Re: Marysville Corporate Center BSP – *Final Review 1*  
PA22004

After reviewing the application Final Binding Site Plan (BSP) application materials for the above referenced proposal, the following technical review comments are provided below.

**FINAL BSP Amendments**

INDEX DATA: SEC 28-33 T 31N R 5E WM
SURVEY FOR: PACIFIC REALTY ASSOCIATES, L.P. 15908 47TH AVE NE MARYSVILLE, WA 98271
SNOHOMISH COUNTY, WASHINGTON
SHEET 8 OF 13

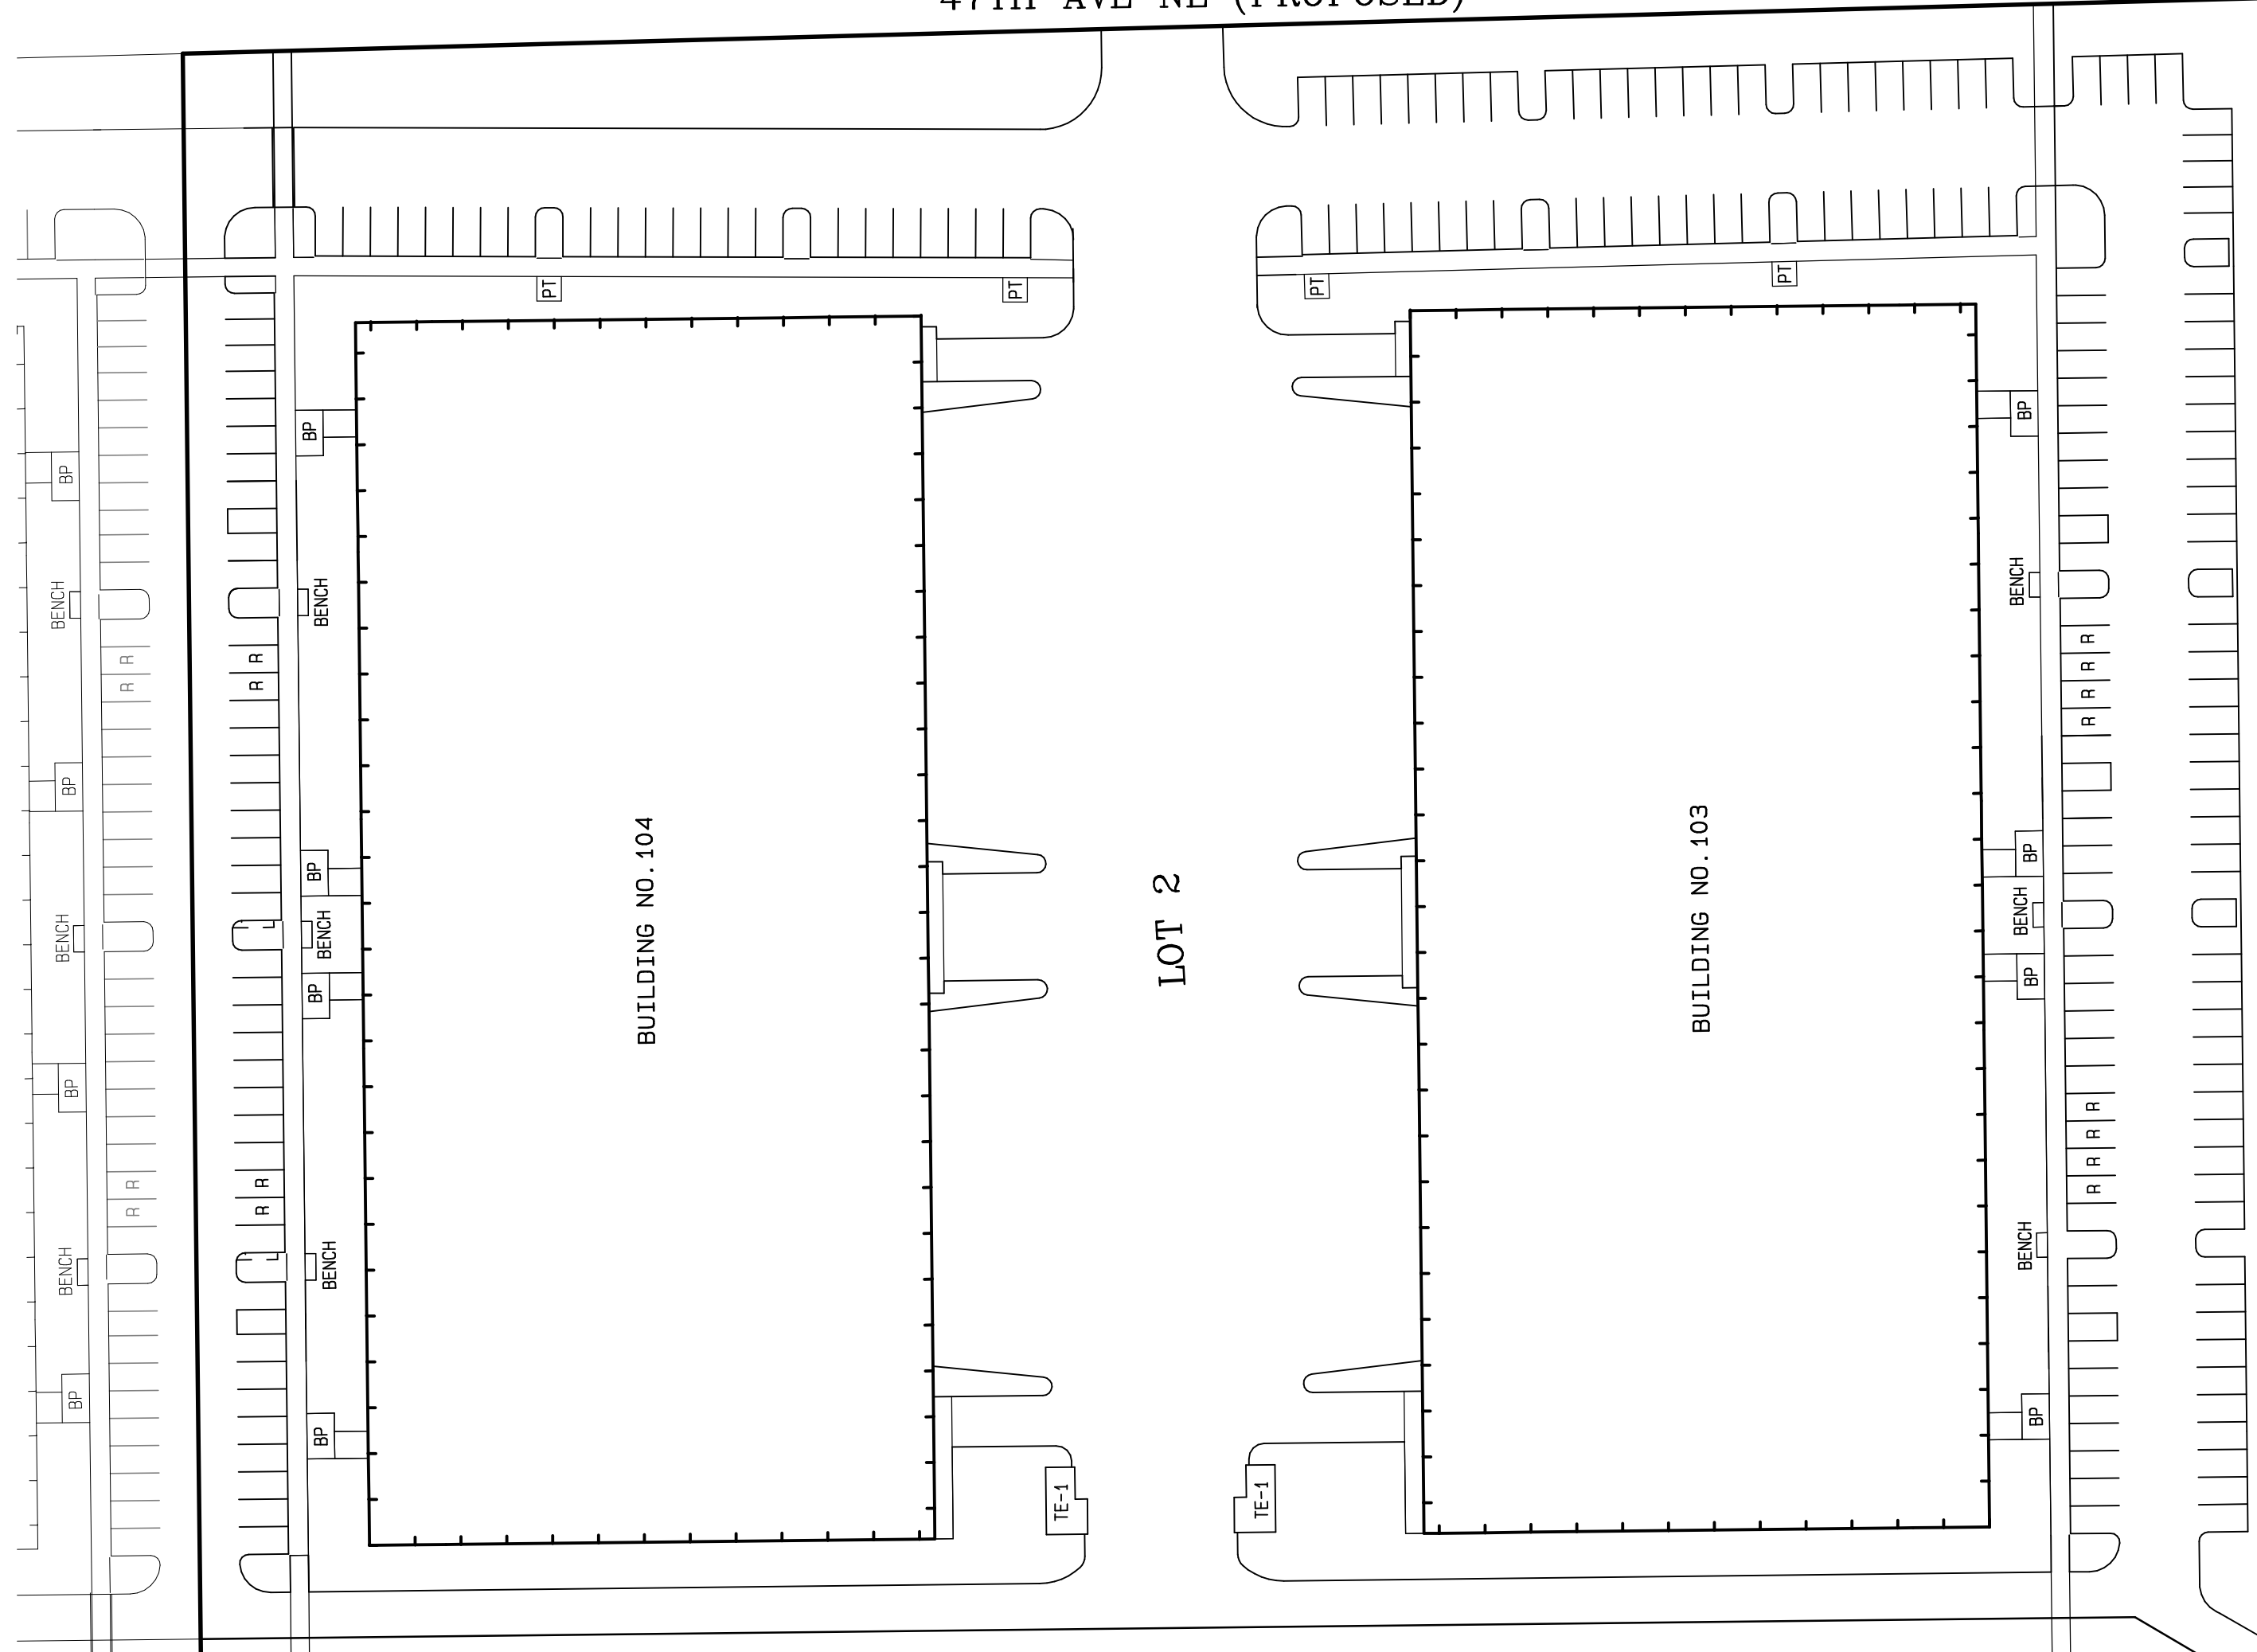
- l. Remove reference to parking stall dimensions.
7. Sheet 8 of 13:
- a. Remove 156<sup>TH</sup> ST NE (~~PROPOSED~~), and amend to read "156<sup>TH</sup> ST NE (HEREBY DEDICATED PUBLIC RIGHT OF WAY)".

- b. Remove 47<sup>TH</sup> AVE NE (~~PROPOSED~~), and amend to read "47<sup>TH</sup> AVE NE (HEREBY DEDICATED PUBLIC RIGHT OF WAY)".
  - c. Remove reference to parking stall dimensions.

INDEX DATA: <b>SEC 28-33 T 31N R 5E WM</b>
SURVEY FOR: PACIFIC REALTY ASSOCIATES, L.P. 15908 47TH AVE NE MARYSVILLE, WA 98271
<b>SNOHOMISH COUNTY, WASHINGTON</b>
<b>SHEET 9 OF 13</b>

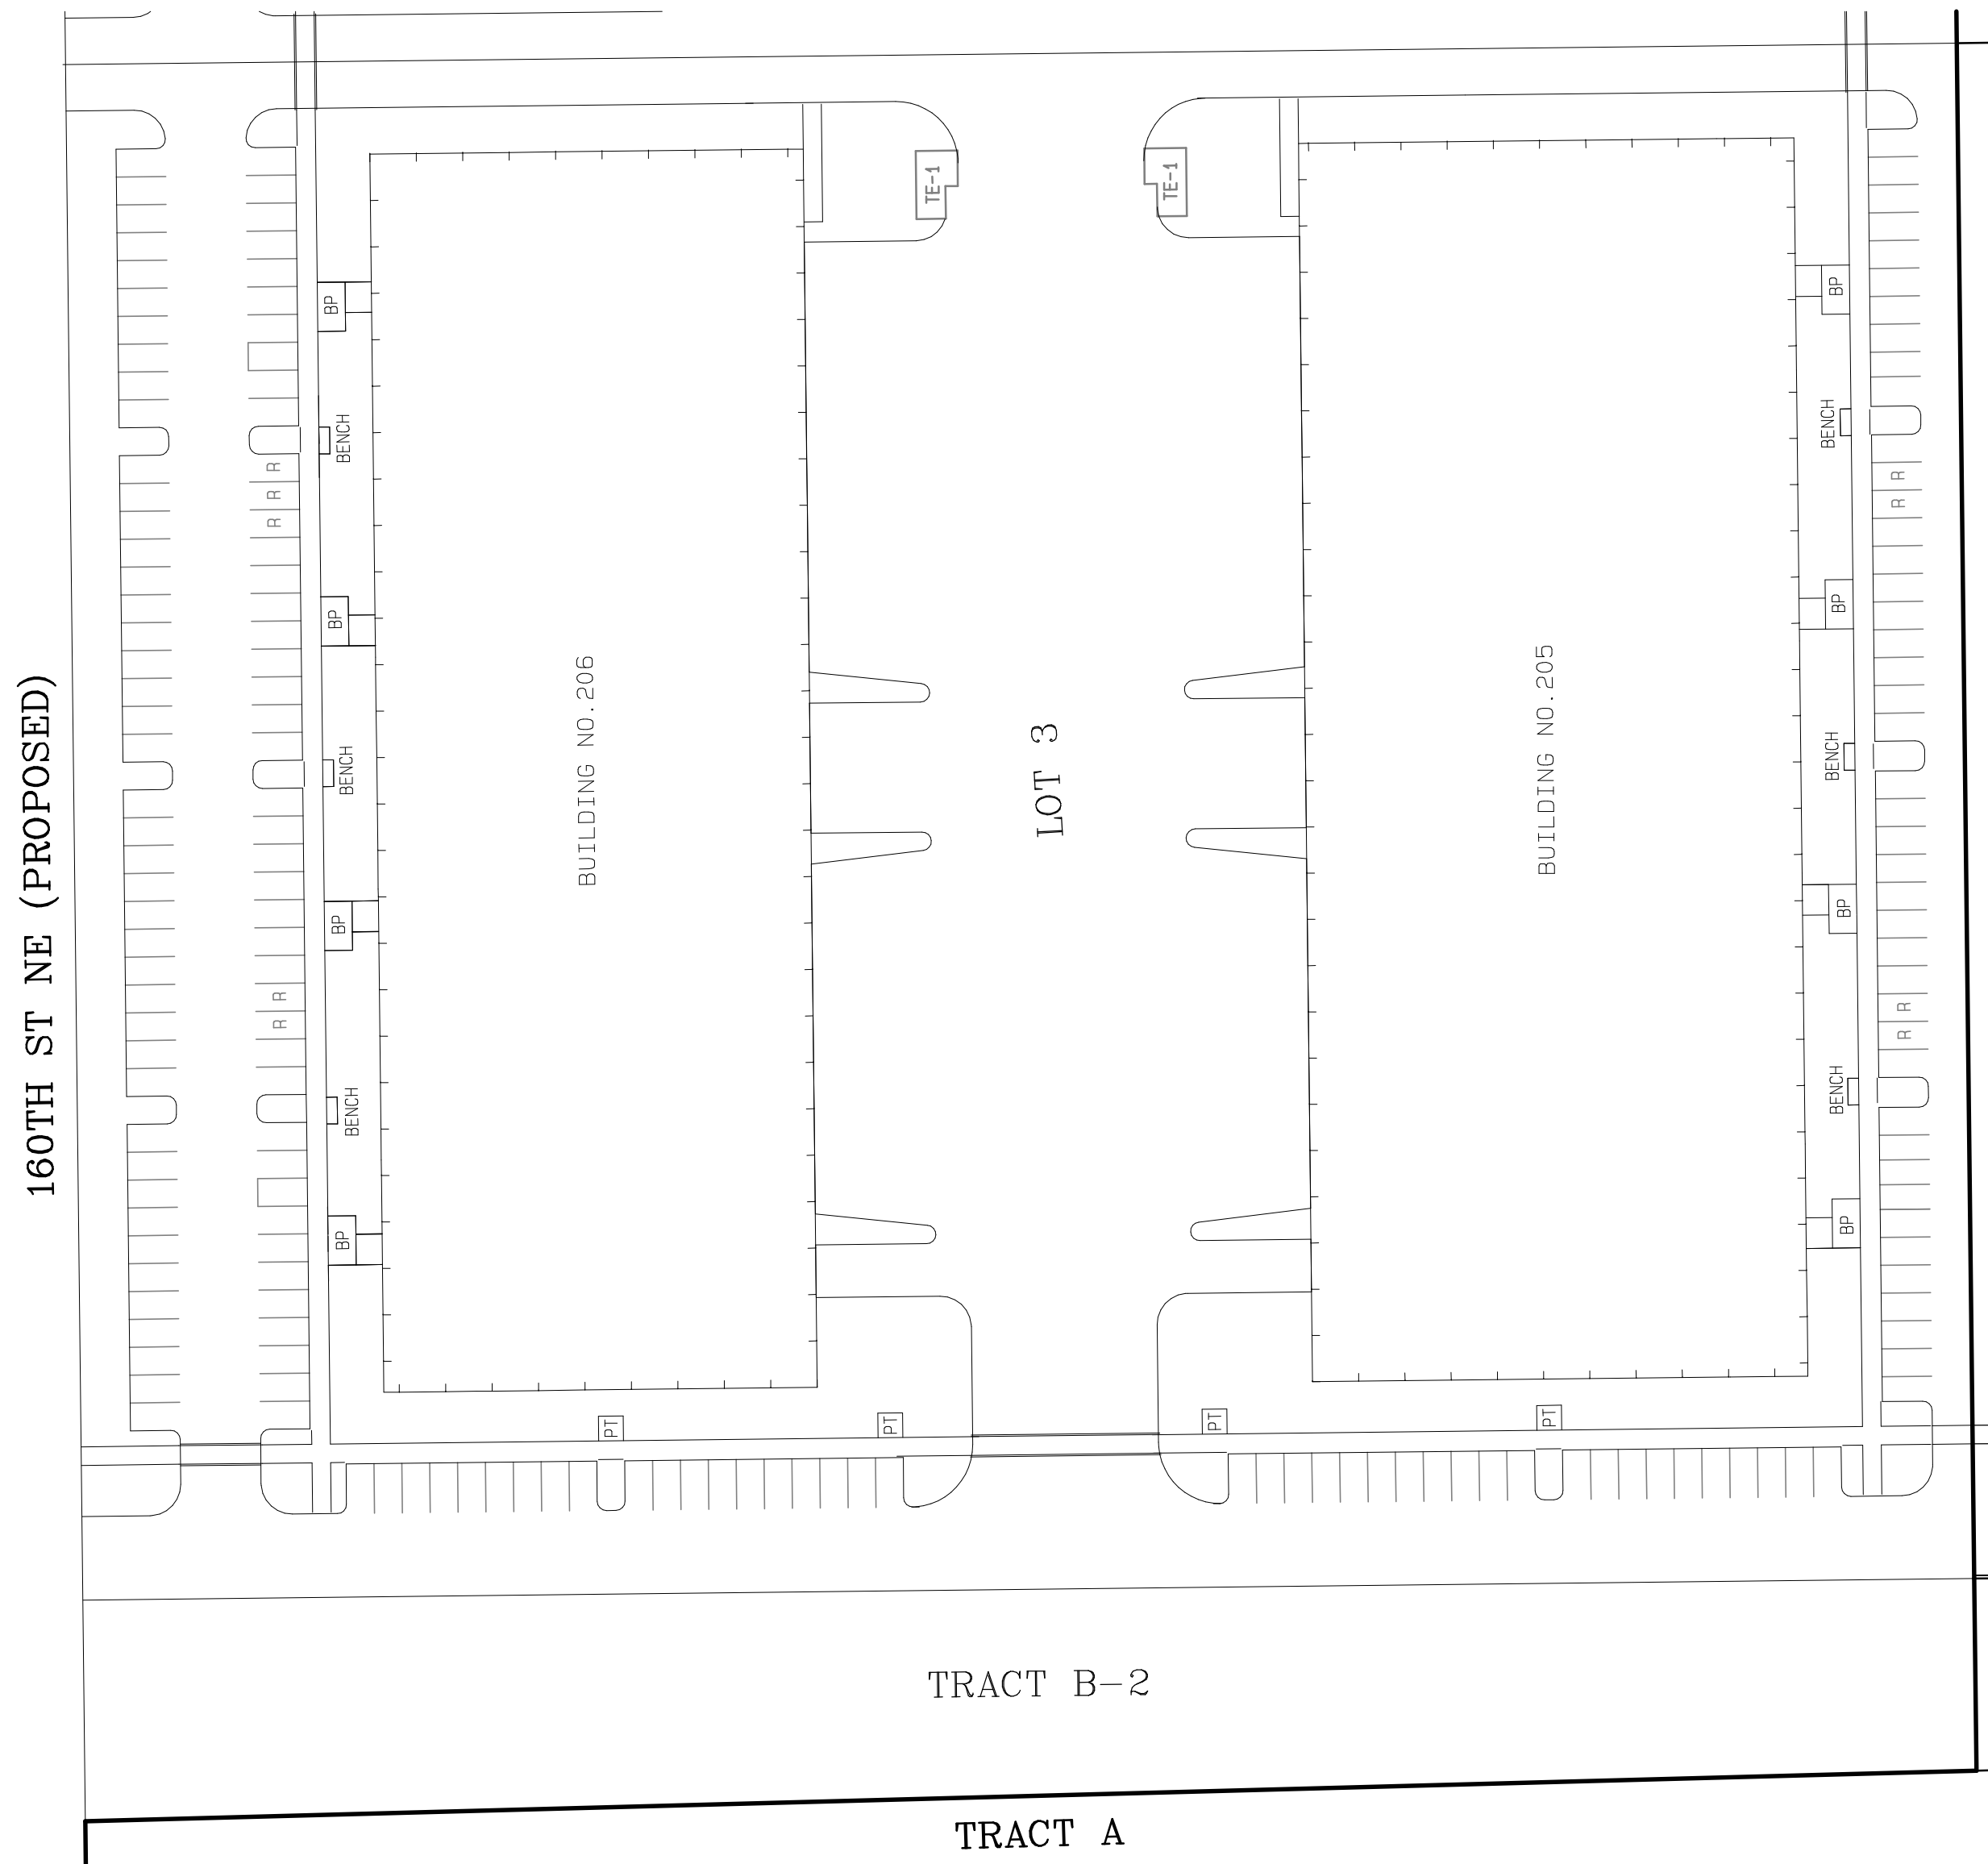
8. Sheet 9 of 13:
- a. Remove 156<sup>TH</sup> ST NE (~~PROPOSED~~), and amend to read "156<sup>TH</sup> ST NE (HEREBY DEDICATED PUBLIC RIGHT OF WAY)".
  - b. Remove reference to parking stall dimensions.

INDEX DATA: SEC 28-33 T 31N R 5E WM
SURVEY FOR: PACIFIC REALTY ASSOCIATES, L.P. 15908 47TH AVE NE MARYSVILLE, WA 98271
SNOHOMISH COUNTY, WASHINGTON
SHEET 11 OF 13

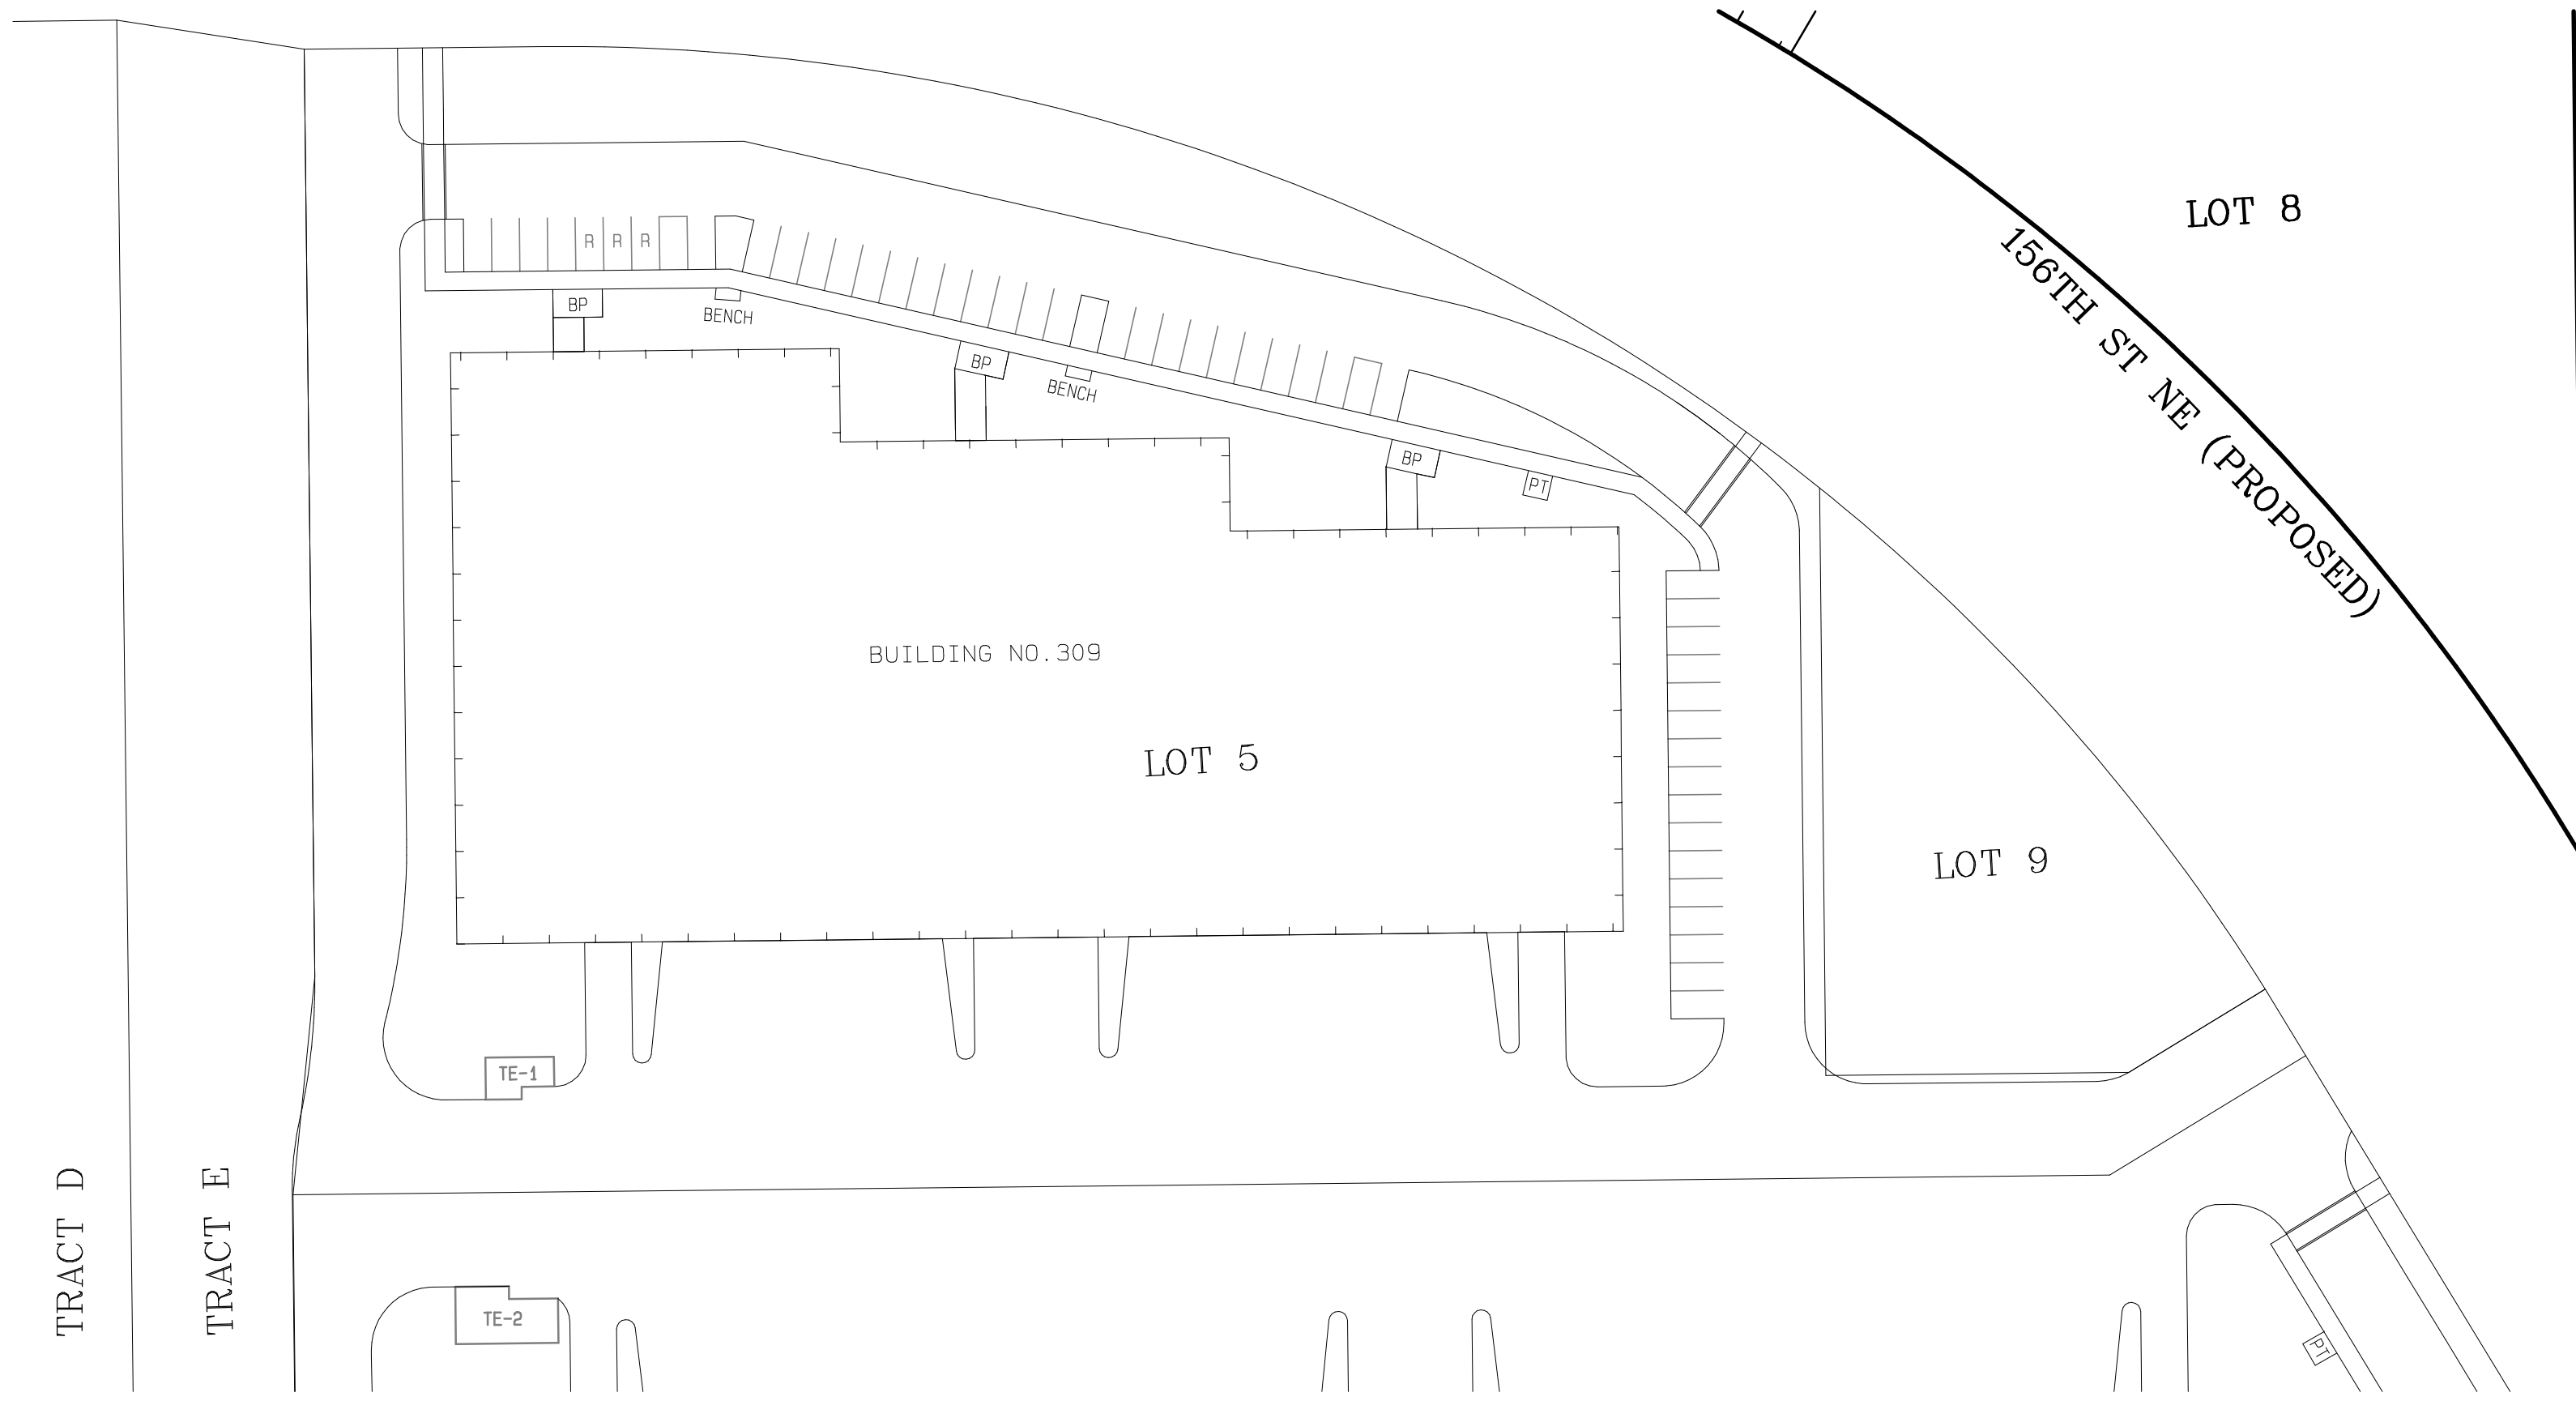
10. Sheet 11 of 13: Remove from FINAL BSP Set.
11. Sheet 12 of 13: Remove from FINAL BSP Set.
12. Sheet 13 of 13: Remove from FINAL BSP Set.
